File Ref. No: BFS19/1999
TRIM Ref. No: D19/53894
Contact: Stephan Netting

**Re: DEVELOPMENT APPLICATION – SYDNEY FOOTBALL STADIUM
(Stage 2 Design, Construction and Operation)
40-44 DRIVER AVENUE, MOORE PARK (SSD-9835)**

I refer to the Department of Planning Industry and Environment's letter dated 17 June 2019 inviting comment from Fire and Rescue NSW (FRNSW) on the proposed redevelopment of the Sydney Football Stadium (SFS).

### C.1 Hydraulic Services Plan

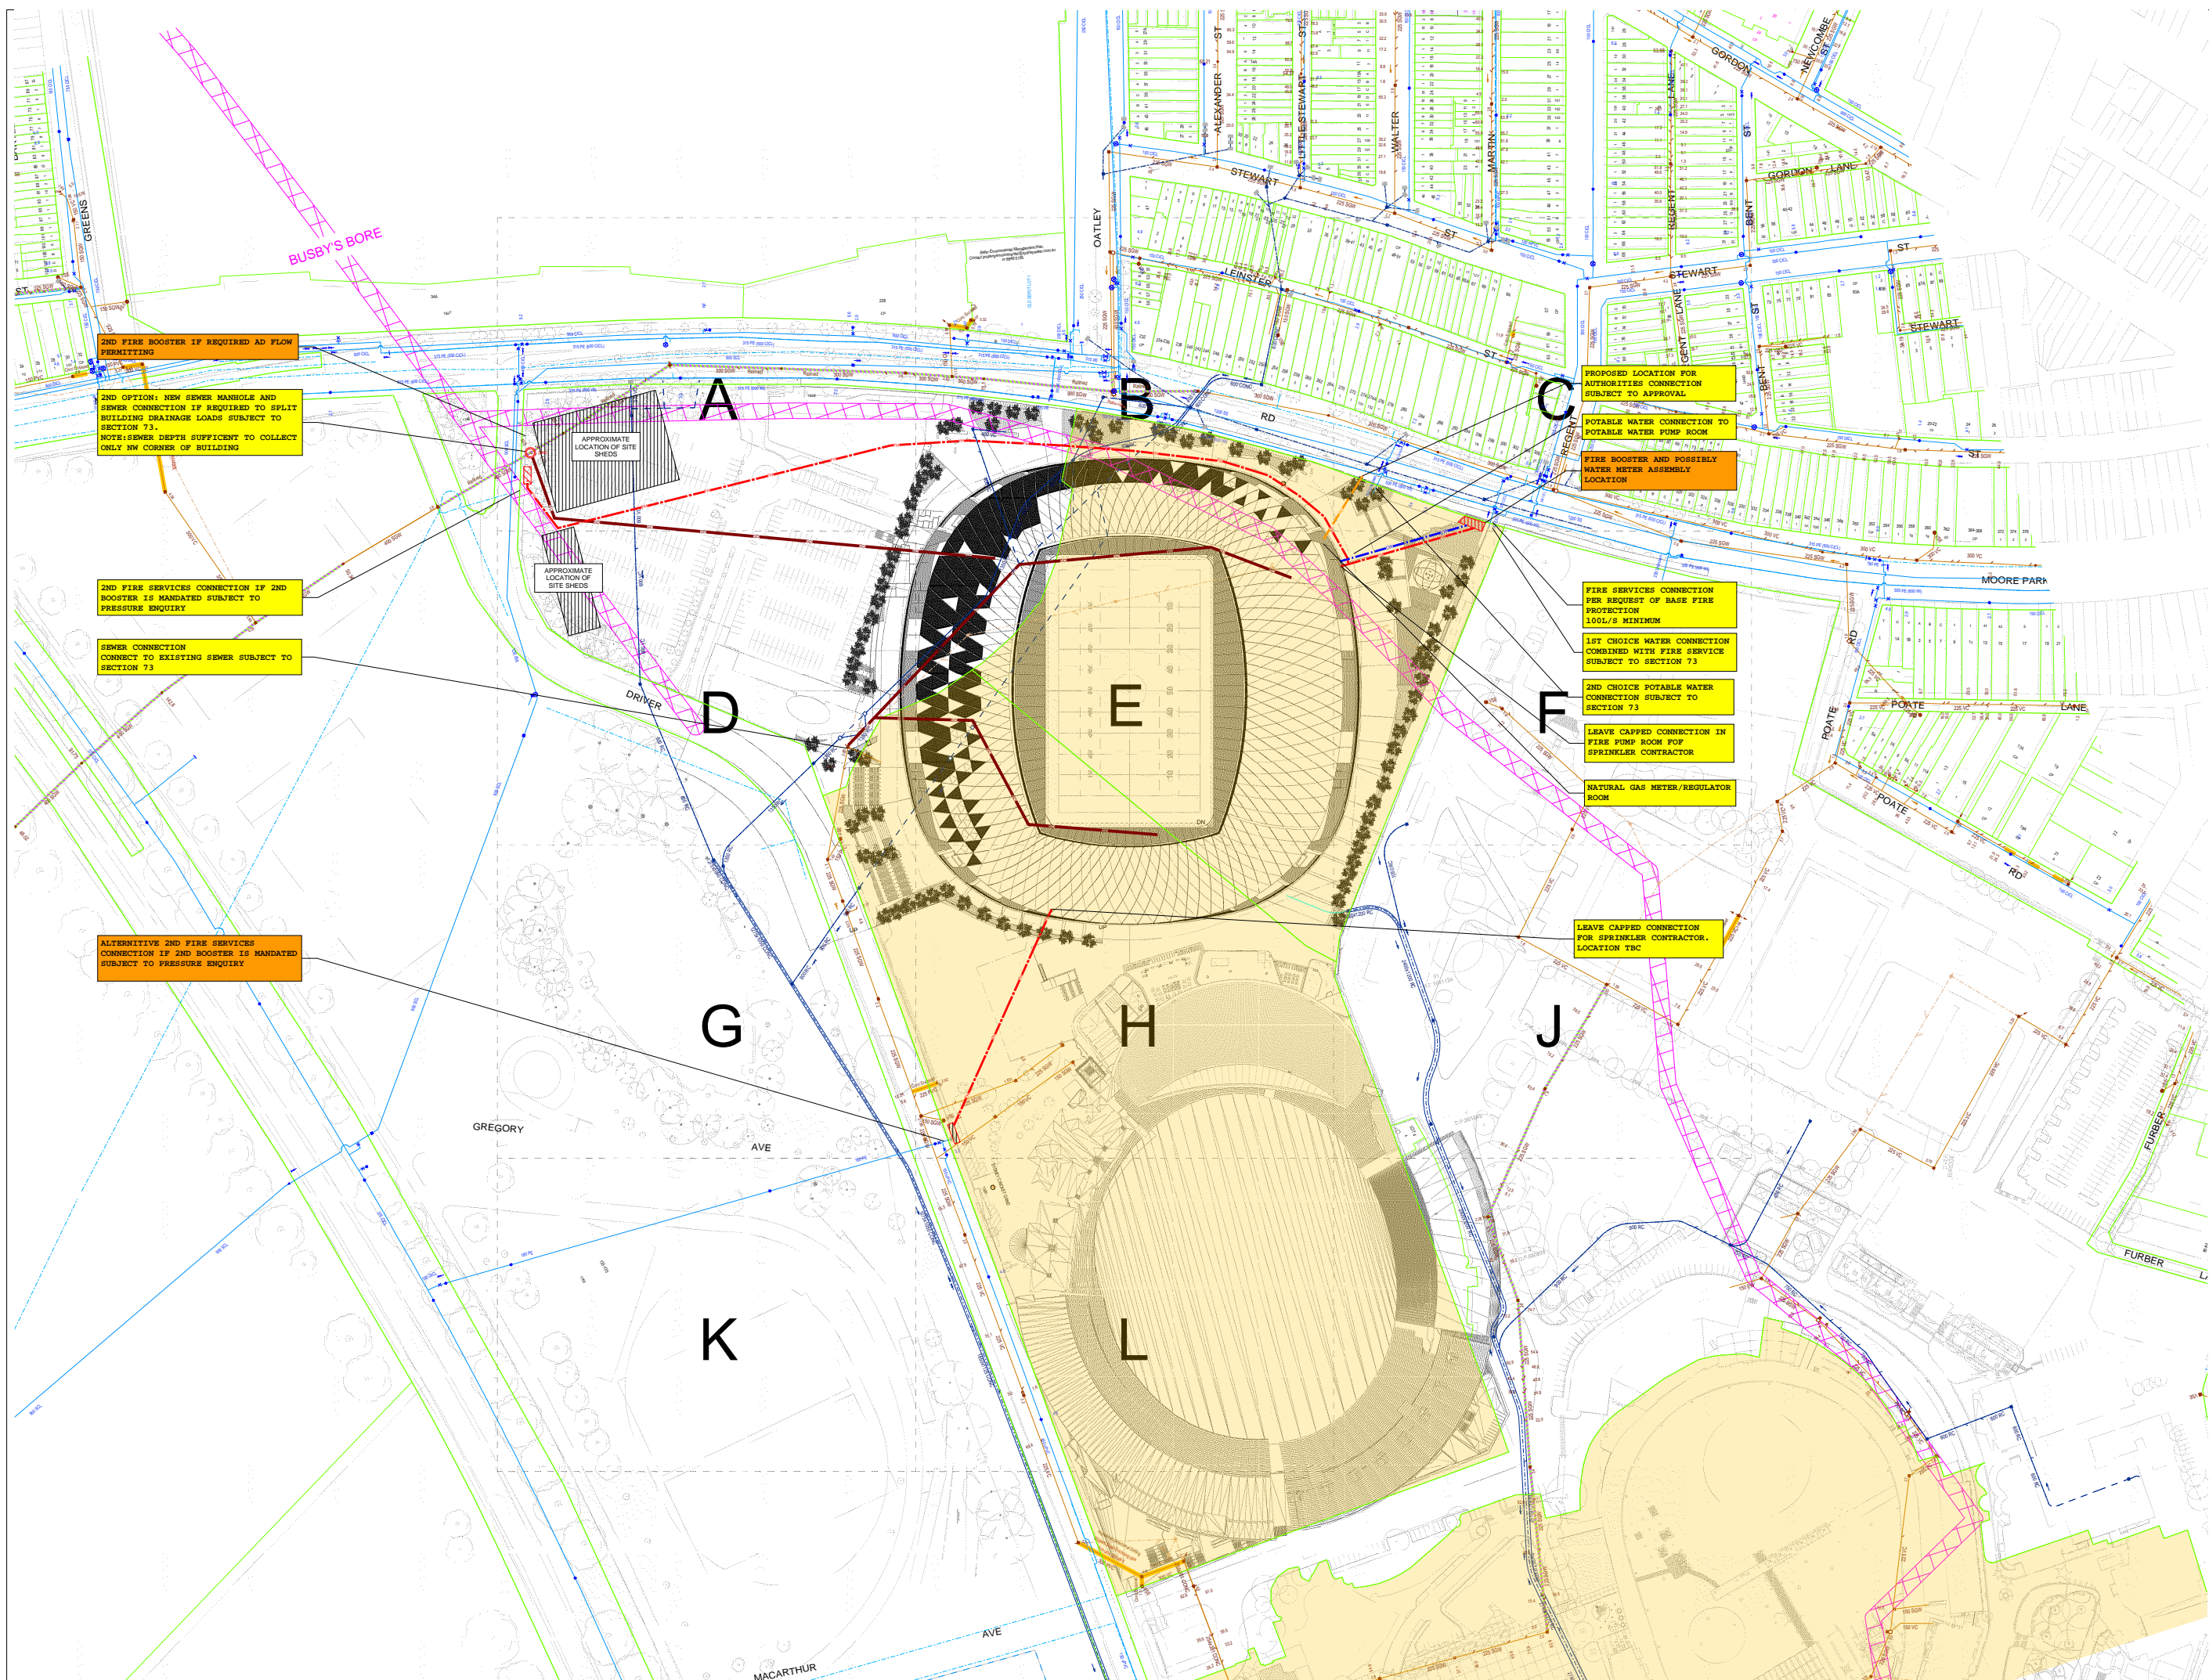
FRNSW notes that Fire Booster Connection locations are proposed as part of the Hydraulic Services Plan included as part of the Infrastructure Management Plan.

FRNSW has not yet agreed to these locations, particularly in relation to the “2nd Fire Booster” and the “Alternative 2nd Fire Booster” as detailed in the Hydraulic Services Plan. As such FRNSW requests that the Fire Booster Connection locations for the Fire Hydrant and Sprinkler Systems, be subject to FRNSW approval prior to the location being finalised and the installation of these facilities.

- D. The location of the Fire Booster Connections for the Fire Hydrant and Sprinkler Systems serving the Sydney Football Stadium, are to be approved by Fire and

Rescue NSW prior to their location being finalised and the Fire Booster Connections being installed.
